March 16, 2026

RE: PITRE KIA SITE PLAN – FINAL TCL COMMENT RESOLUTION LETTER FOR BUILDING PERMIT

Planning Department – Sertil A. Kanbar:

KIA_WESTSIDE AUTO_DEALERSHIP	ENGINEER'S SEAL RONALD R. BOHANNAN NEW MEXICO 7868 PROFESSIONAL ENGINEER 06/18/25 RONALD R. BOHANNAN P.E. #7868	DRAWN BY MR DATE 06/18/2025
	FINAL TRAFFIC CIRCULATION PLAN	SHEET # TCL-1	JOB # 2024019

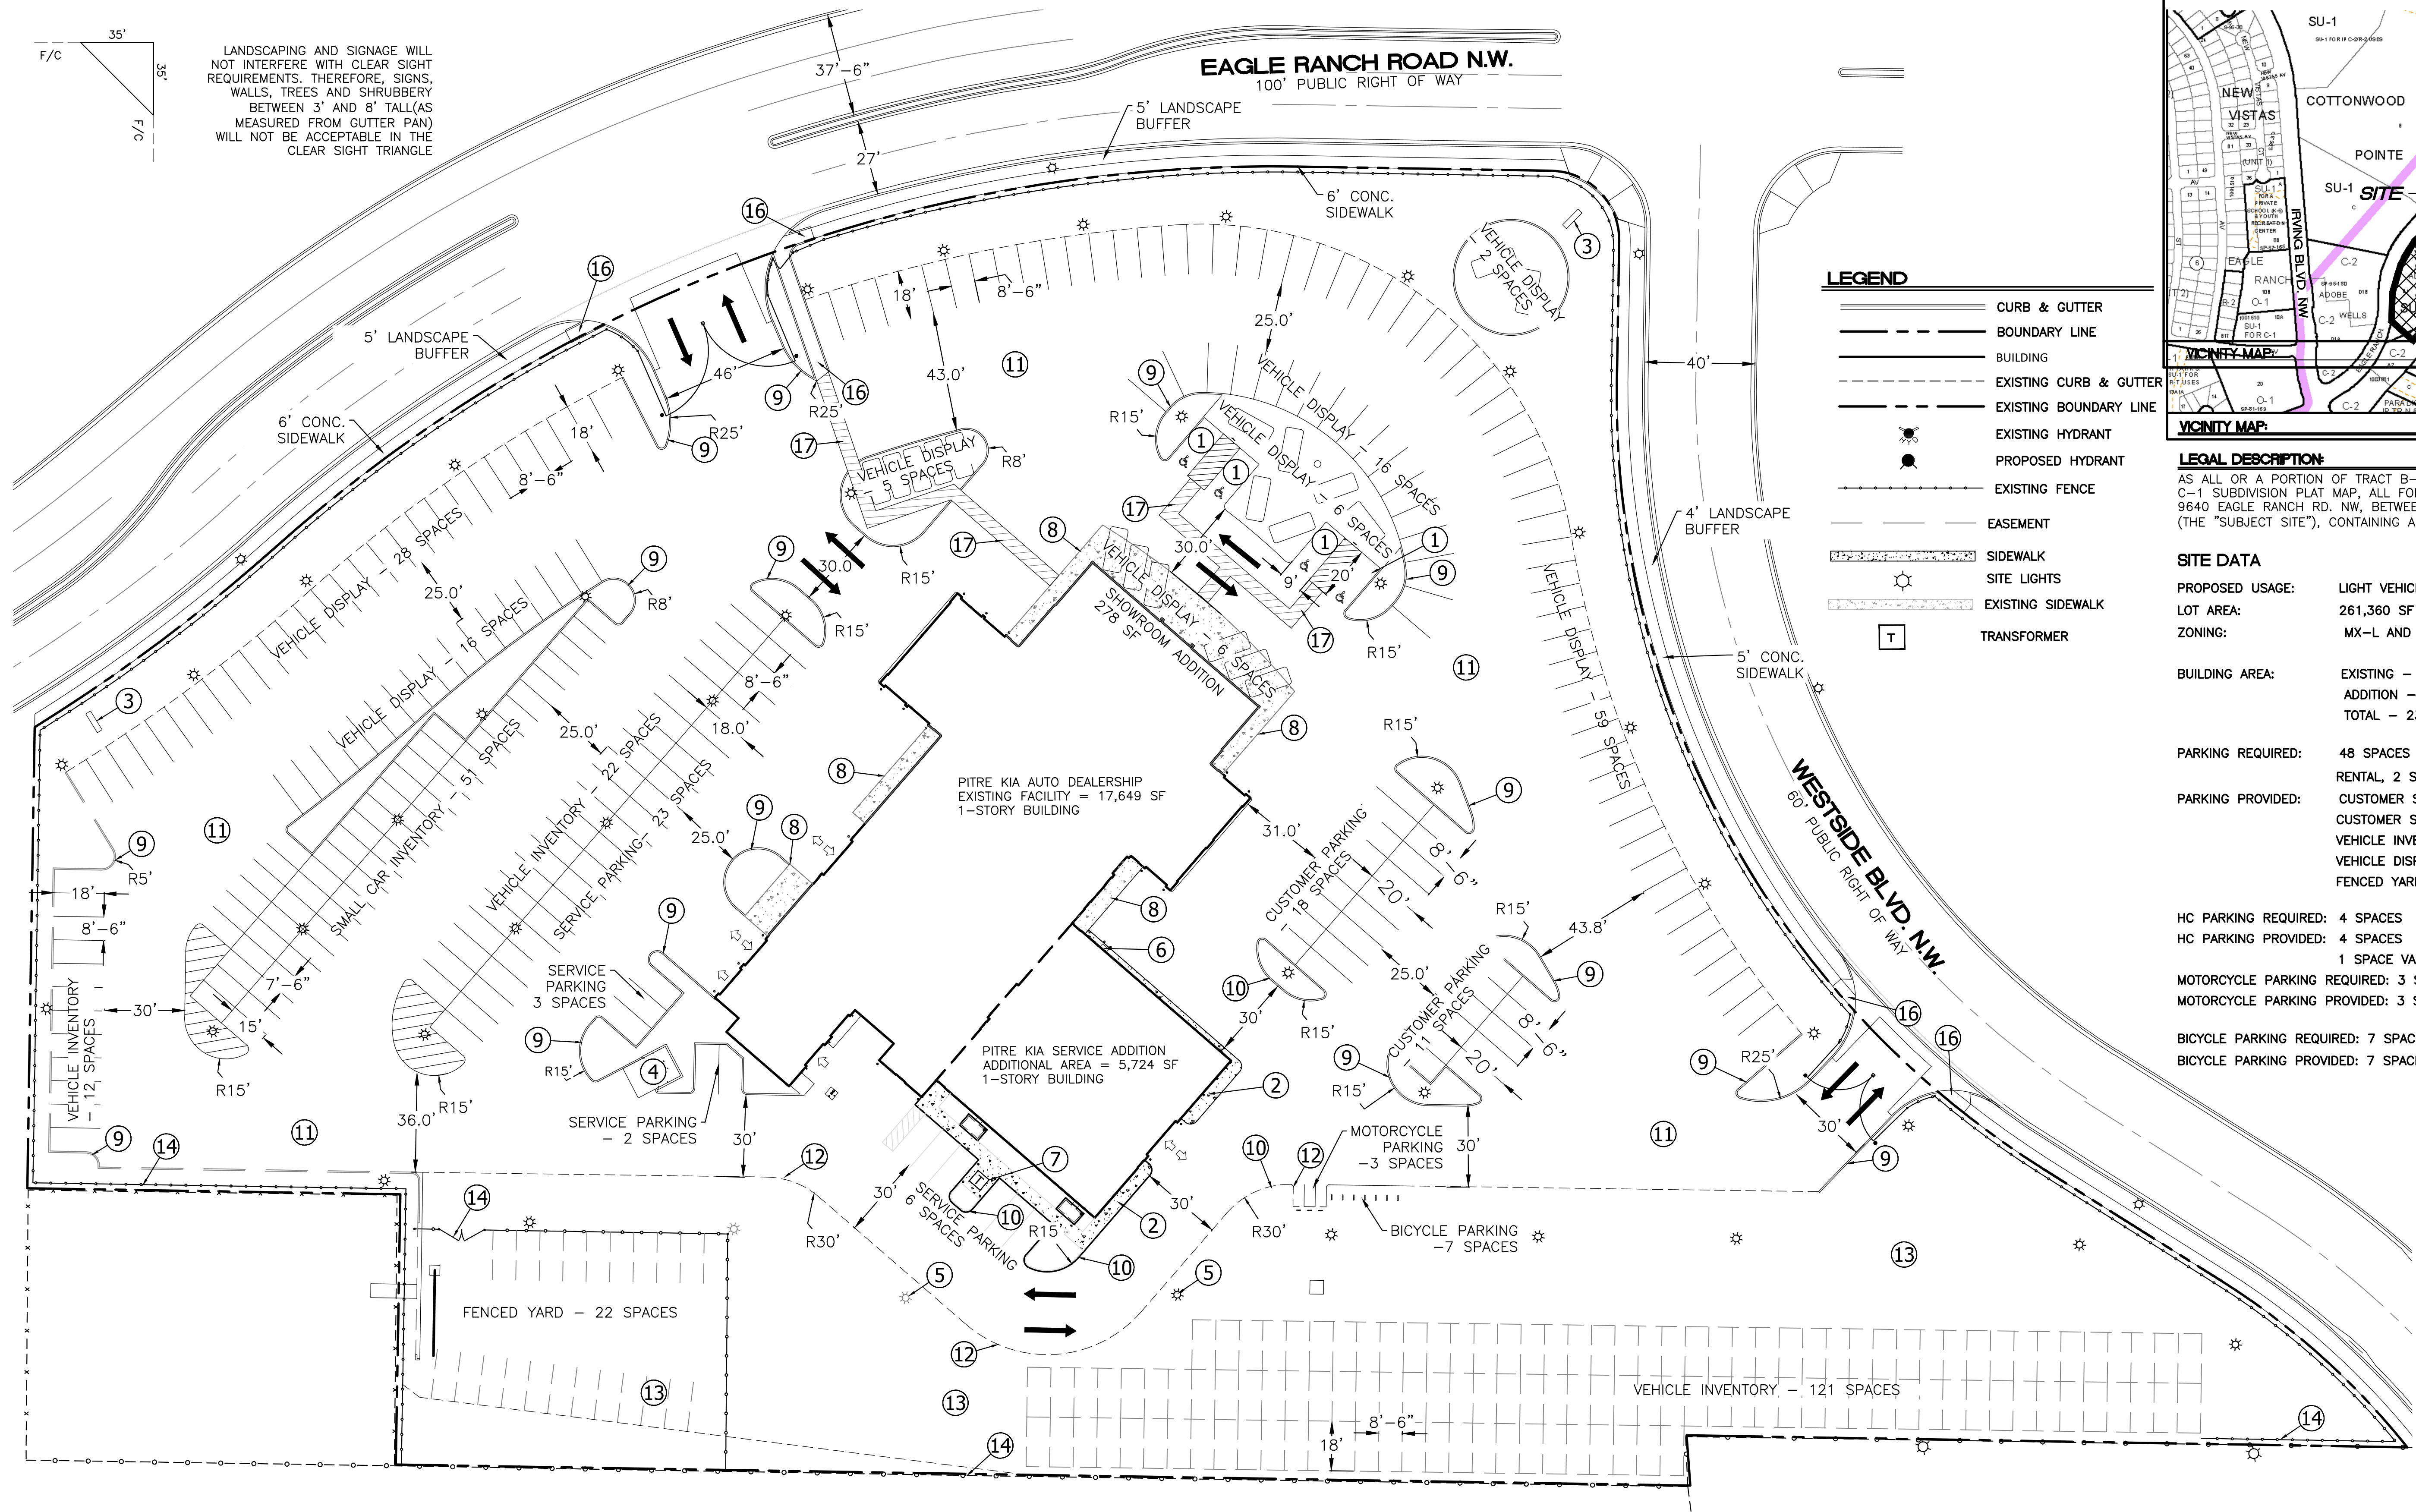
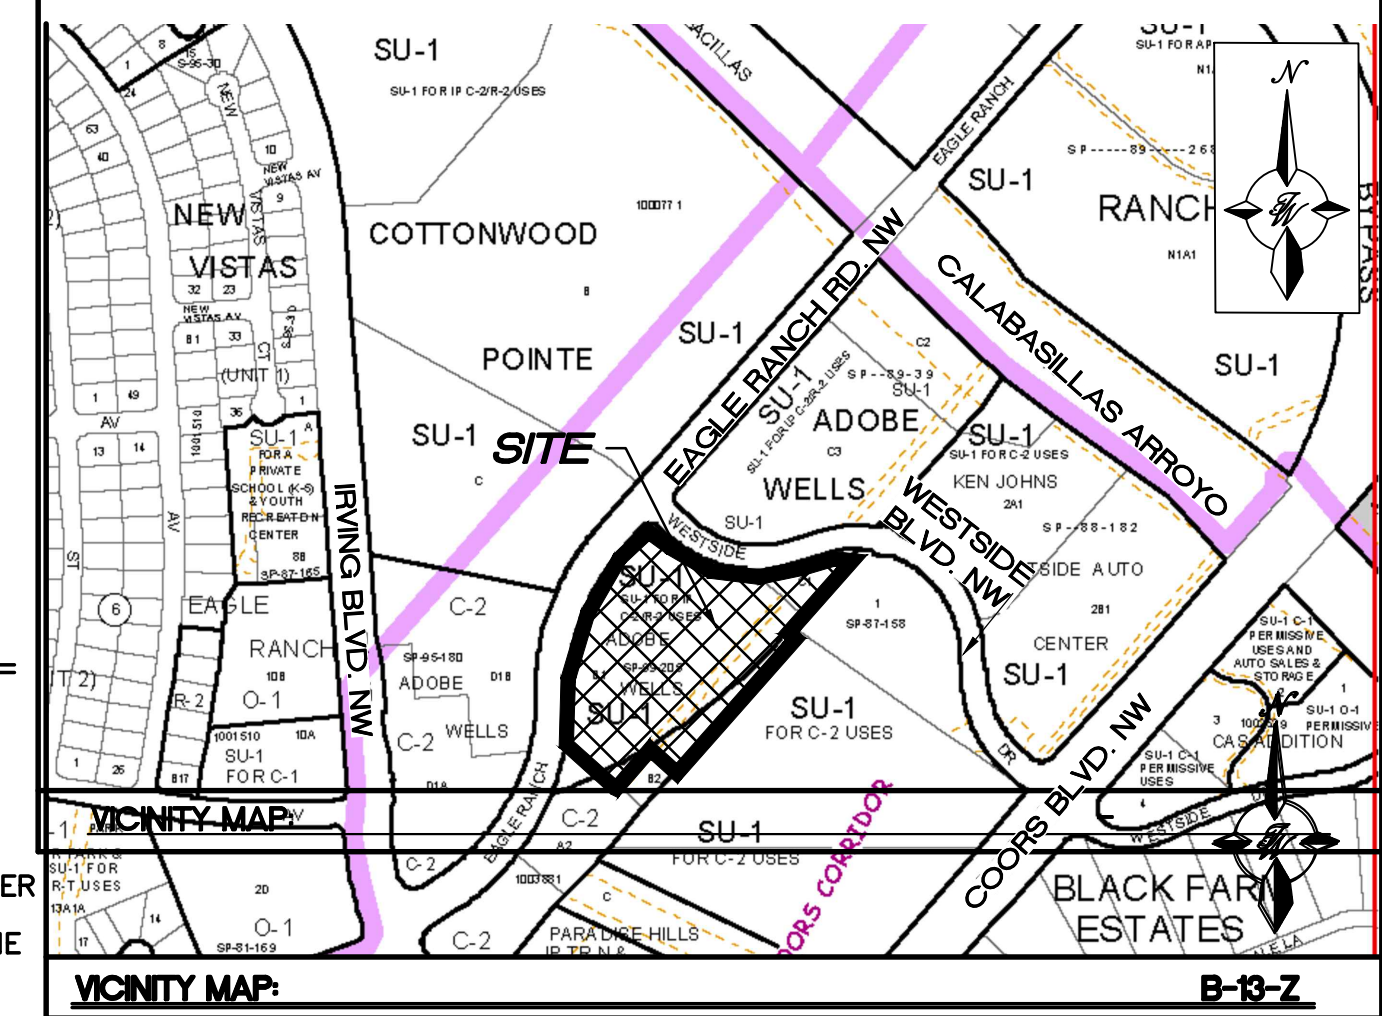
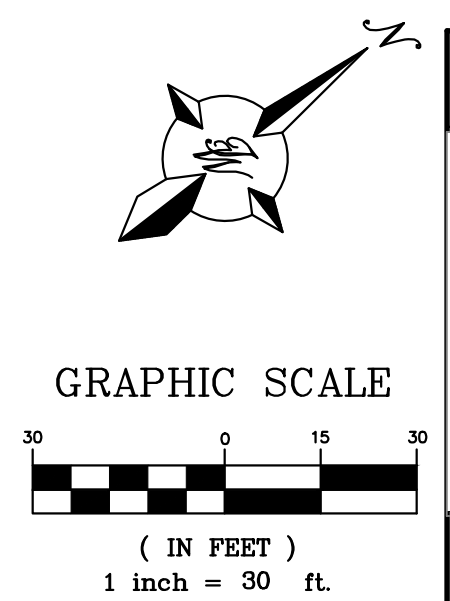
1. When submitting TCL for building permit approval, please ensure that:
 - a. Pedestrian access width keyed note 17 is 6 ft.

- b. Show the widths of sidewalk and buffer along both streets

- c. Upgrade the accessible ramps at the entrances.

- d. Add a keyed note stating to replace any broken sidewalks.

i. Note 17 updated,

(17) 6' PEDESTRIAN ACCESS

i. Notes included,

i. Note 16 updated,

(16) EXISTING ACCESSIBLE RAMP TO BE UPGRADED/REHABILITATED

i. General Note 1 included,

1. ALL BROKEN SIDEWALK SHALL BE REMOVED AND REPLACED ALONG WITH IMPROVEMENTS
